1-1 INDUSTRIAL ZONE
APPLICATION FOR PERMIT

980 Riverside St.

Permit to construct a 1-story masonry and frame warehouse 50' x 40' at the above named location is being issued subject to the following Building Code requirements:

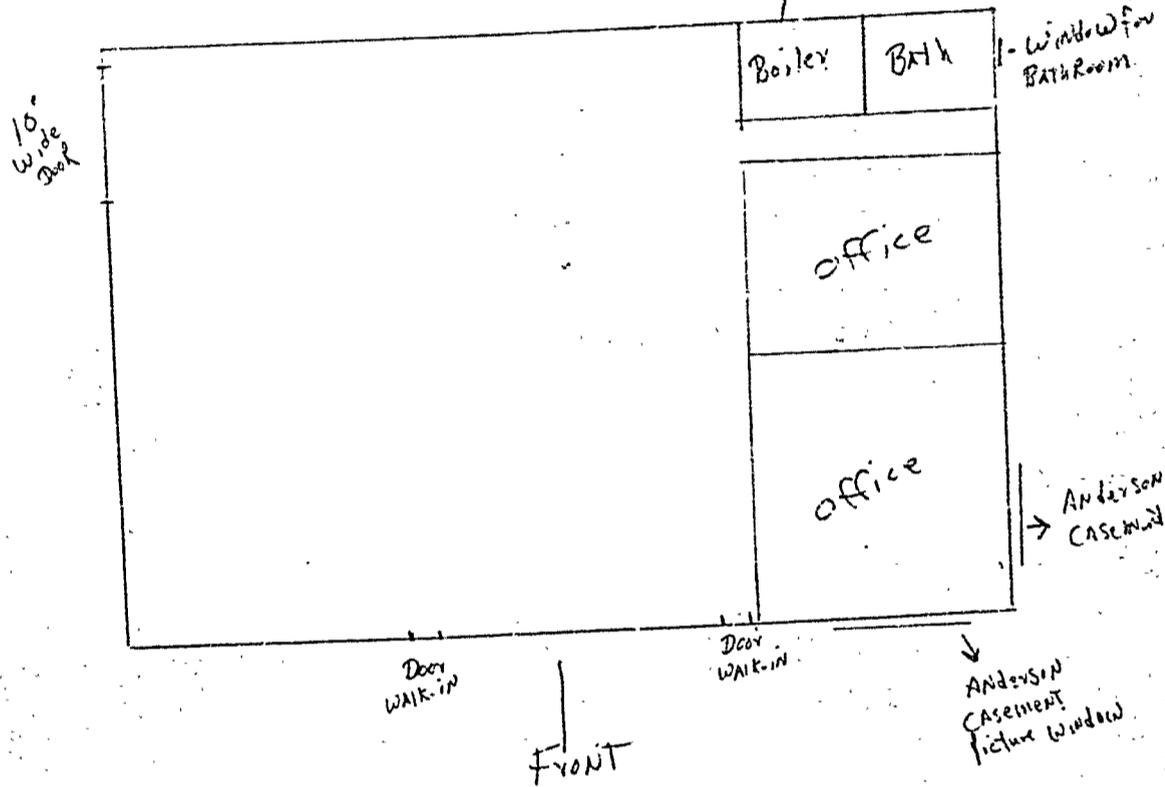
1. Before any installation of roof trusses we will need a section describing how these trusses will be tied to the masonry walls.
2. The angle irons which you propose to use over your 7 foot casement windows will require a statement of design or you may use one of these normal precast lintels which are available.
3. We will also need to know the type of roof covering you plan to use.
